Markup Summary

Cursory redlines Steve Kuehster 9/25/2019

GRADING & EROSION CONTROL PLAN

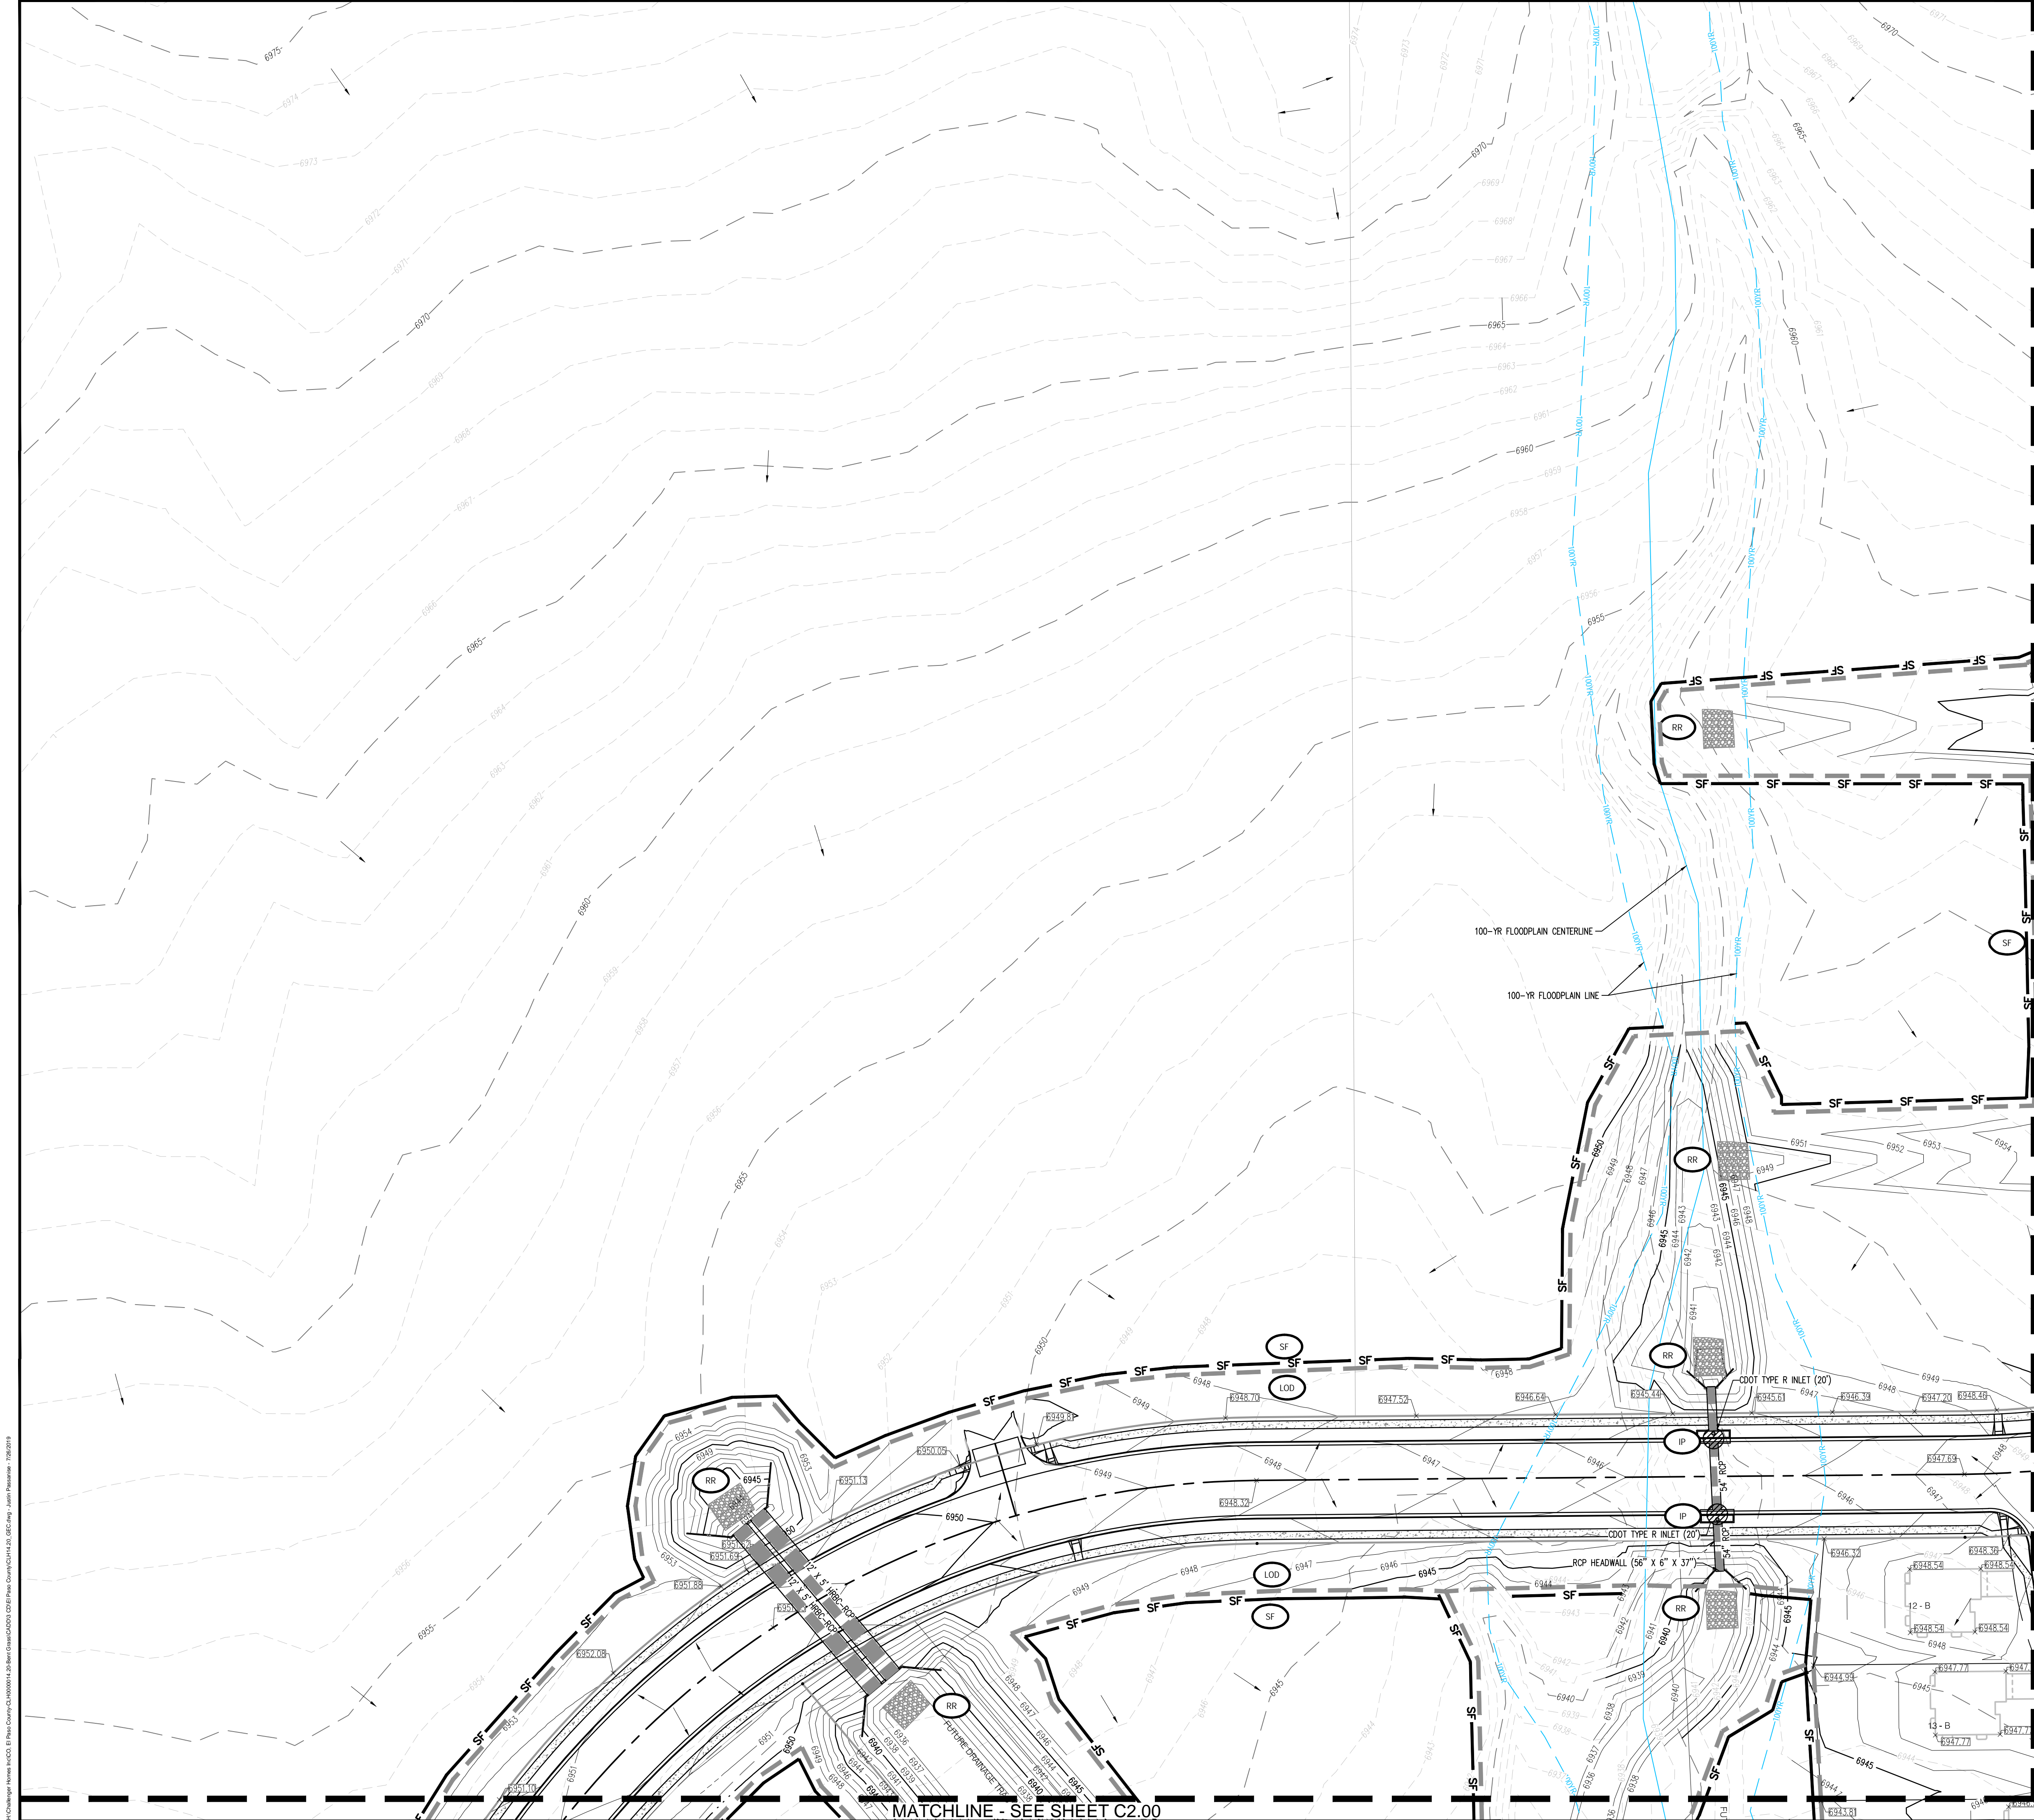
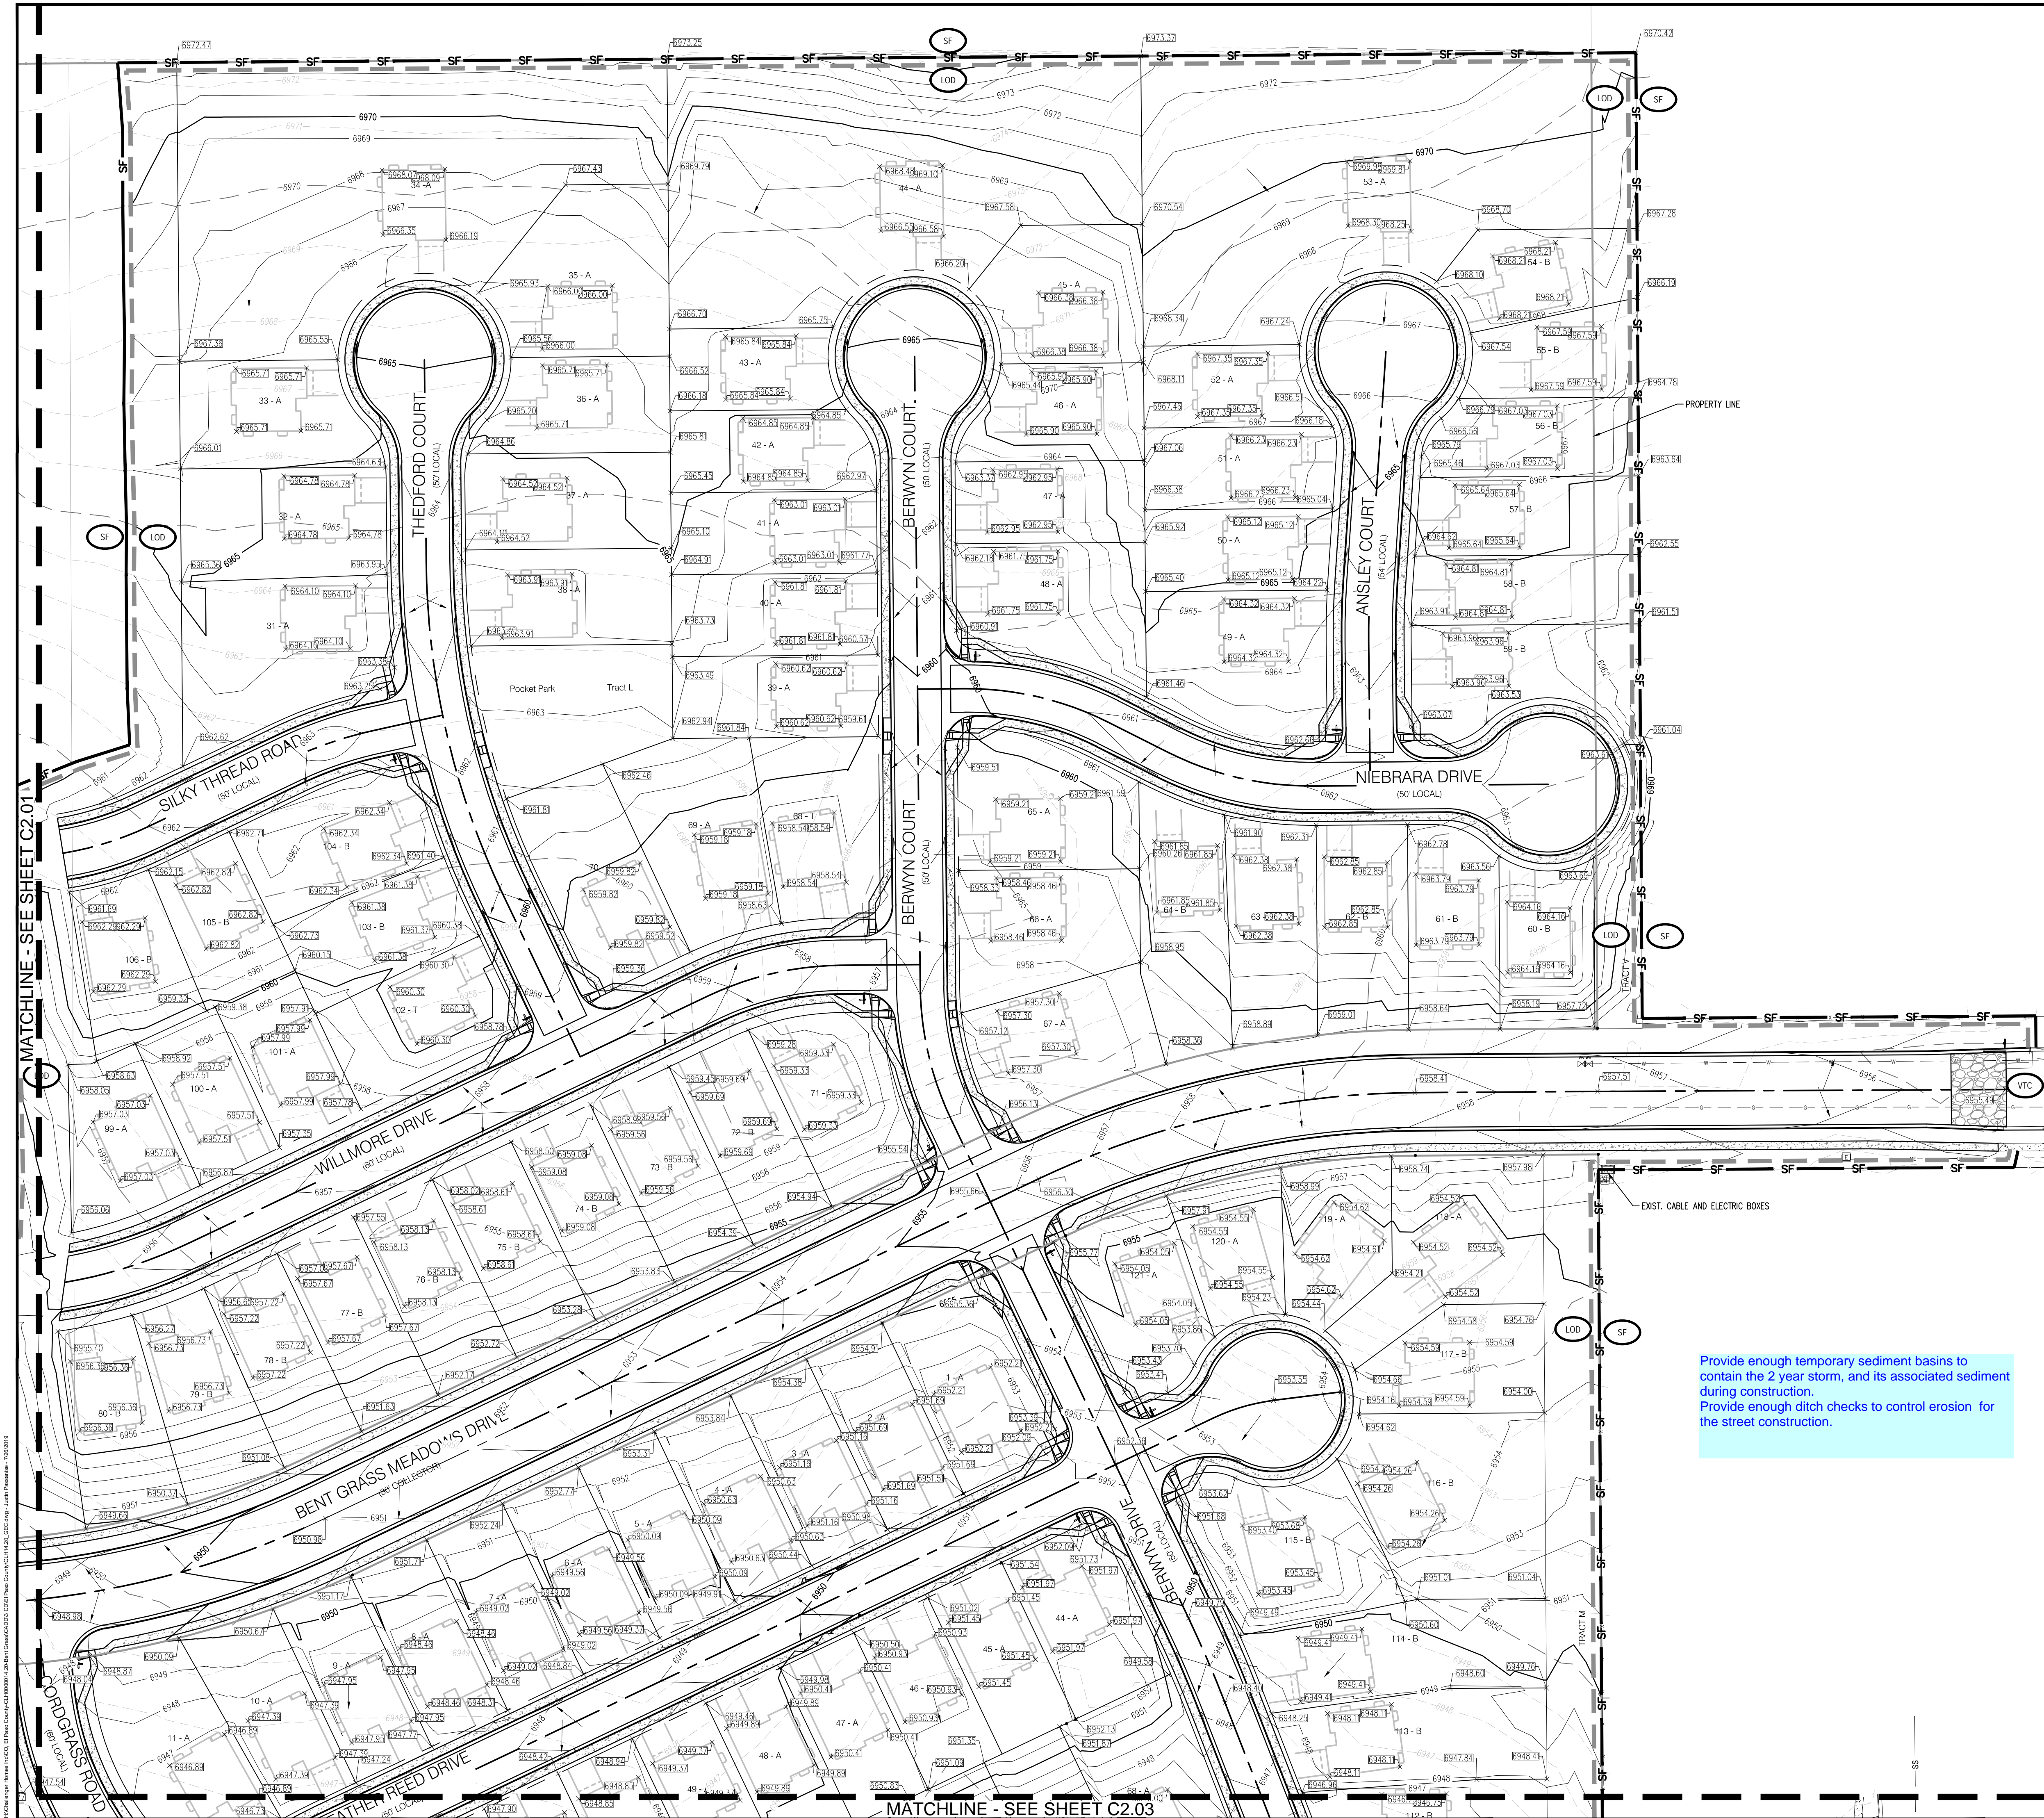
Provide details for all rip rap dissipater proposed; Size, Dimensions, etc.

Call out slopes. 3;1, 4;1 etc.

See comments on the Drainage report. These channels need to be improved /Stabilized.

Provide enough temporary sediment basins to contain the 2 year storm, and its associated sediment during construction.
Provide enough ditch checks to control erosion for the street construction.
